From: Amber Willard
Sent: 22 October 2018 12:59
To: Karen Parsons
Subject: FW: Chimney at 28 The Drive

Dear Ms Willard,
We note that you are now the designated case officer for our application ref AW/177/18/HH.
I am forwarding an email below that we sent to Mr Castro-Parker in September, following the report from Martyn White (conservation officer) which supported our application.
Our email was not added to the portal and I just wanted to check that it was on the record.

DATE/DRAWN BY:	27 /04/ 18 Drawn by JS
CLIENT:	Mike & Alison Terry
PROJECT:	28 The Drive, Aldwick
SCALE:	1:100@A3
DRAWING TITLE:	REAR ELEVATION
AS ANDY STEDMAN LANDSCAPE & GARDEN DESIGN

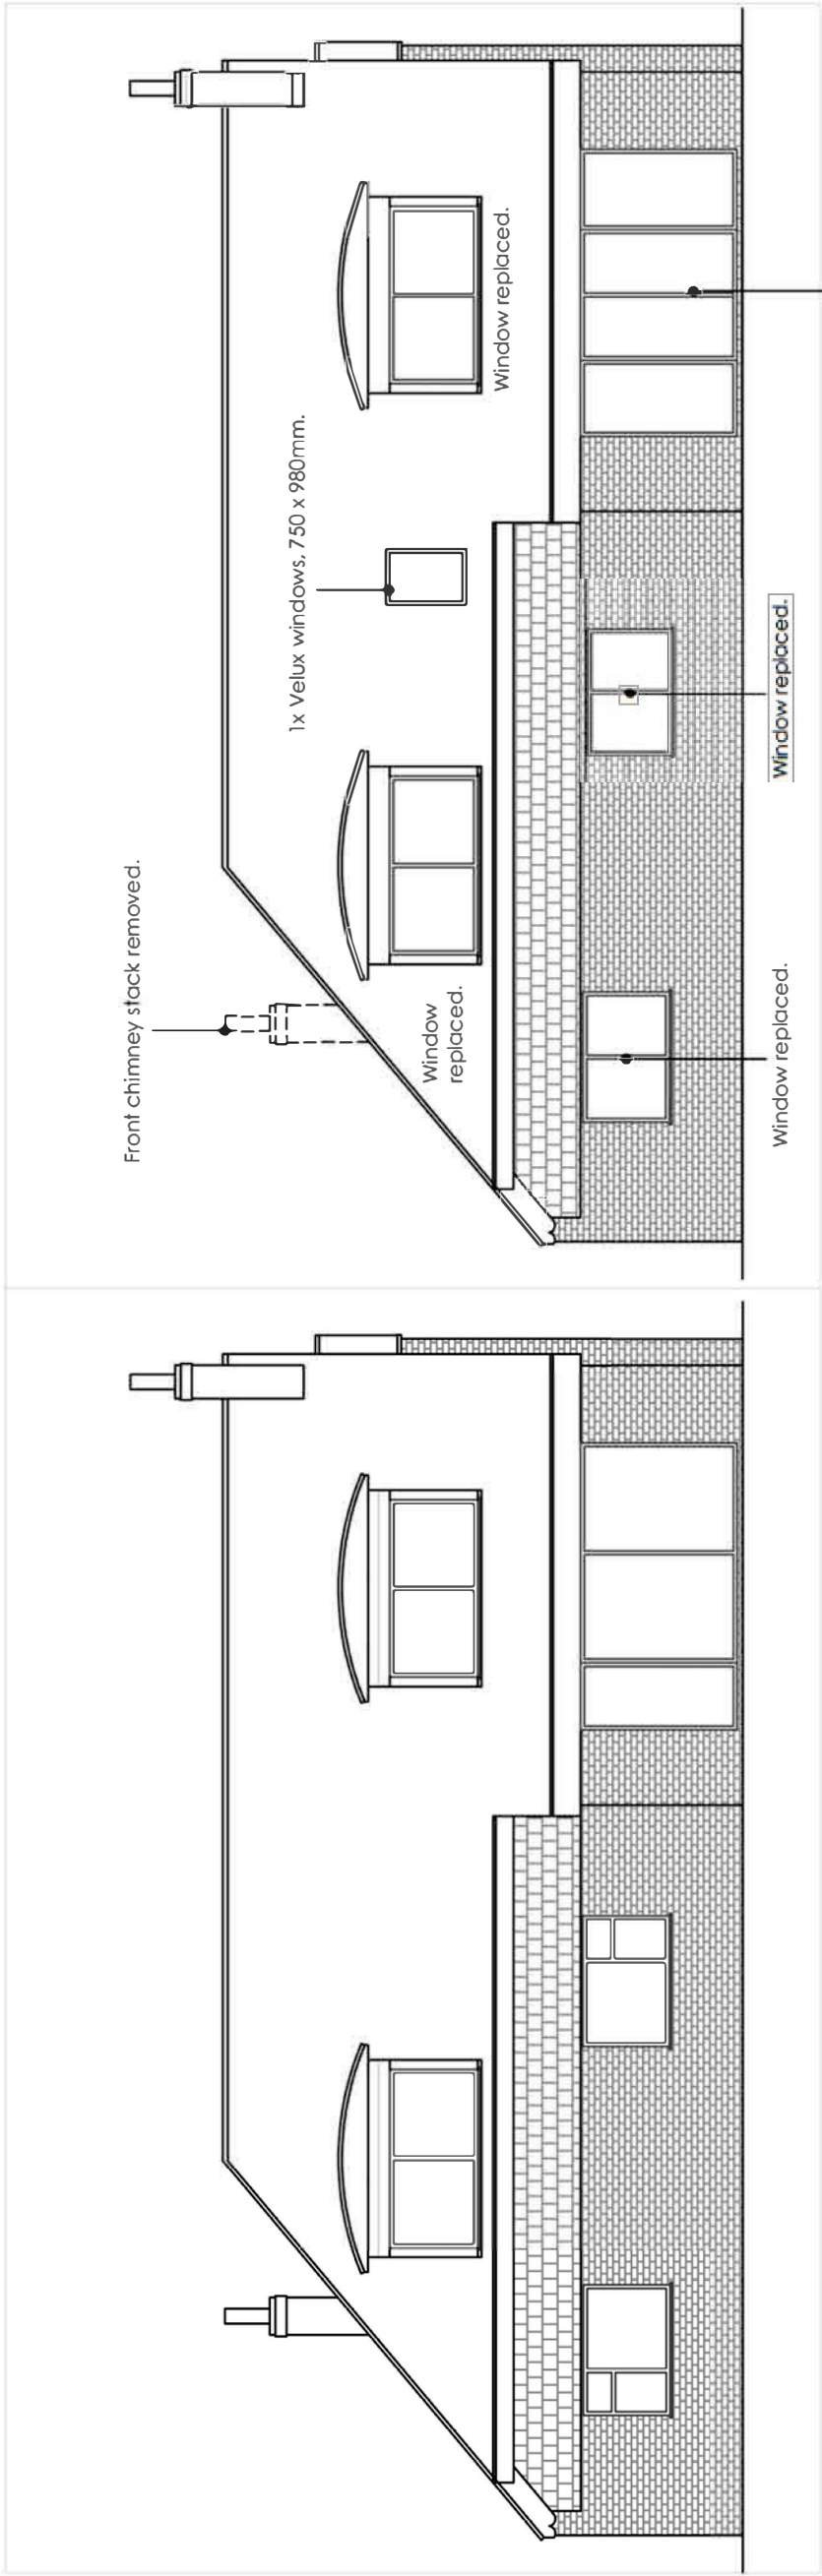
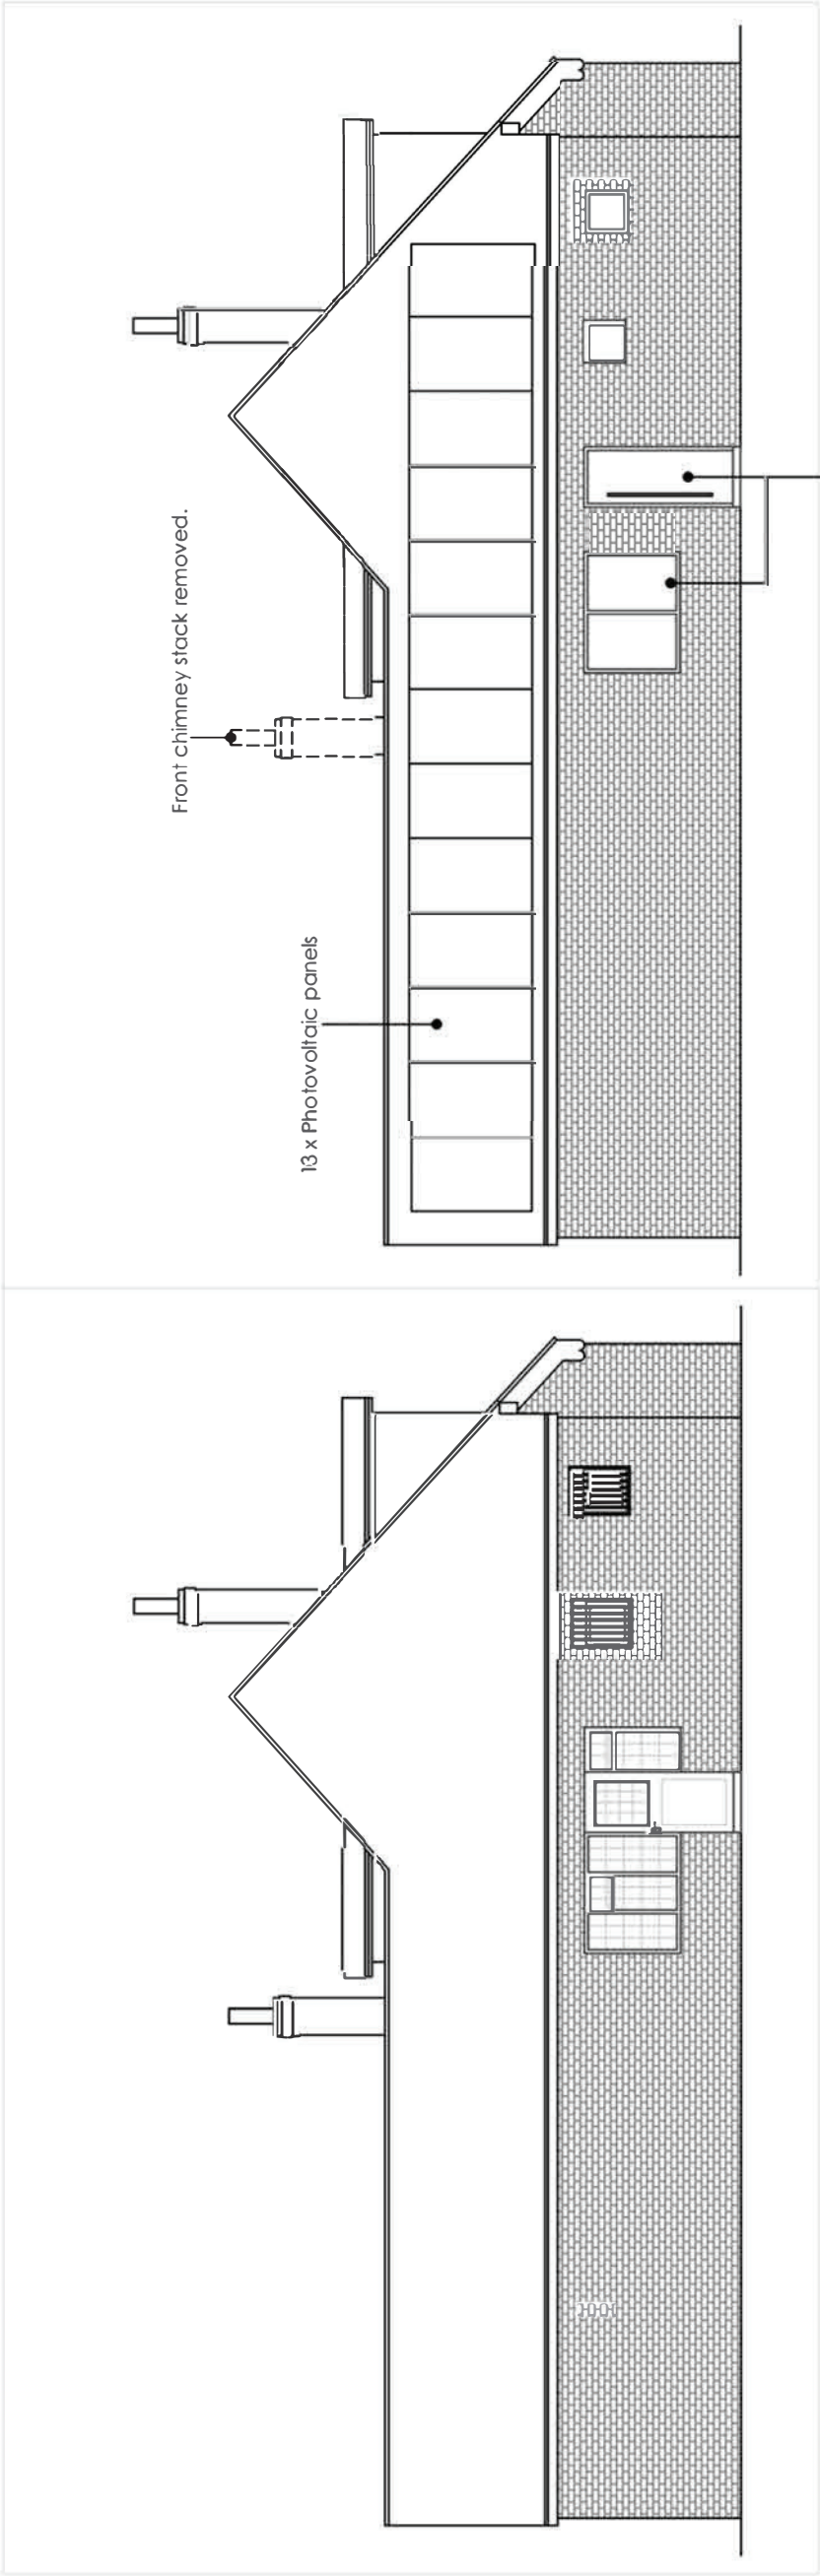
Thank you for clarifying however are you able to send an amended copy with the wording changed to state west elevation. If you able to email a copy, I could upload it, as when we list the approved plans, if the elevation is wrong then technically the plan wouldn't refer to anything as the incorrect information is shown.

I have however noticed that there are two plans labelled as the rear elevation. One of these I believe is the west elevation. Please am I able to get this amended as so when it listed as an approved plan it is correct.

I have amended the title on the attached.

The rear elevation is the South elevation and it is the one correctly labelled with the french doors and the two dormer windows.

The drawing incorrectly labelled as the rear elevation is actually the West elevation and provides a passageway alongside the house.

This is the elevation which has the solar panels.
